From: Amanda Scholes on behalf of Planning.Responses
Sent: 24 May 2018 09:27
To: Planning Scanning
Subject: FW: Y/91/17/OUT

From: Laura Gibbons
Sent: 17 May 2018 13:55
To: David Easton
Cc: Paul Cann
Subject: RE: Y/91/17/OUT

Additional comments relating to surface water drainage:

Groundwater Monitoring Record

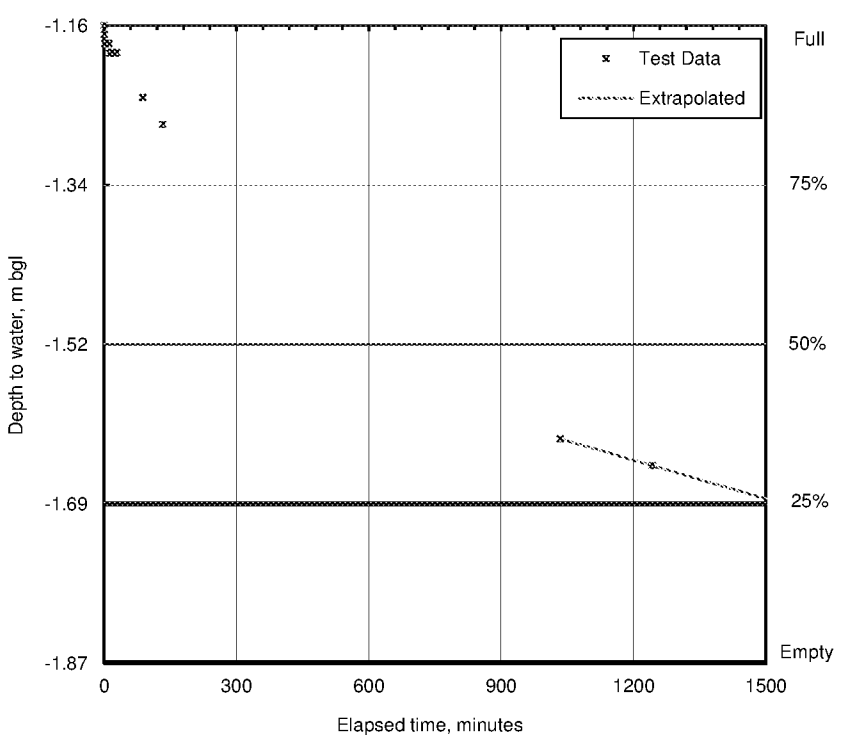
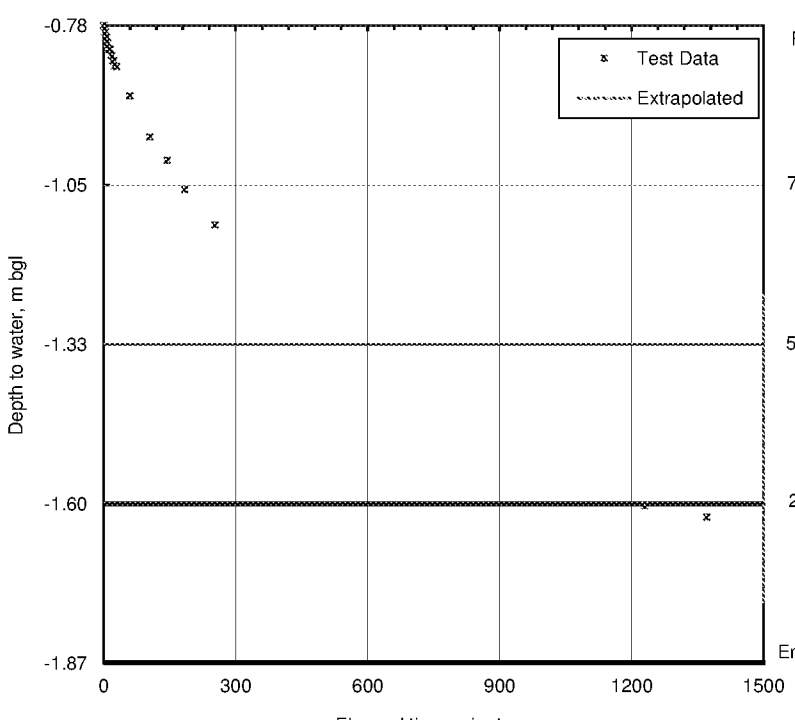
- We note that groundwater monitoring was conducted in late October. For a development of this size, we require monitoring to be completed from October through to March, i.e. the current monitoring results are insufficient.
- Discharge rates of $\times 10^{-6}$ are not poor enough to justify ruling out infiltration in the surface water drainage strategy. Infiltration is achievable at such a rate. Therefore, the overall strategy would need to be revised.
- A plan showing the locations of percolation test pits would also be required.
- We do not require 1m clearance between the base of any proposed infiltration structure and maximum recorded groundwater levels. Therefore, a maximum recorded groundwater level of 1.69m bgl is not too high to rule out the use of infiltration. Shallow infiltration structures can be used with maximum groundwater levels of 1m bgl.
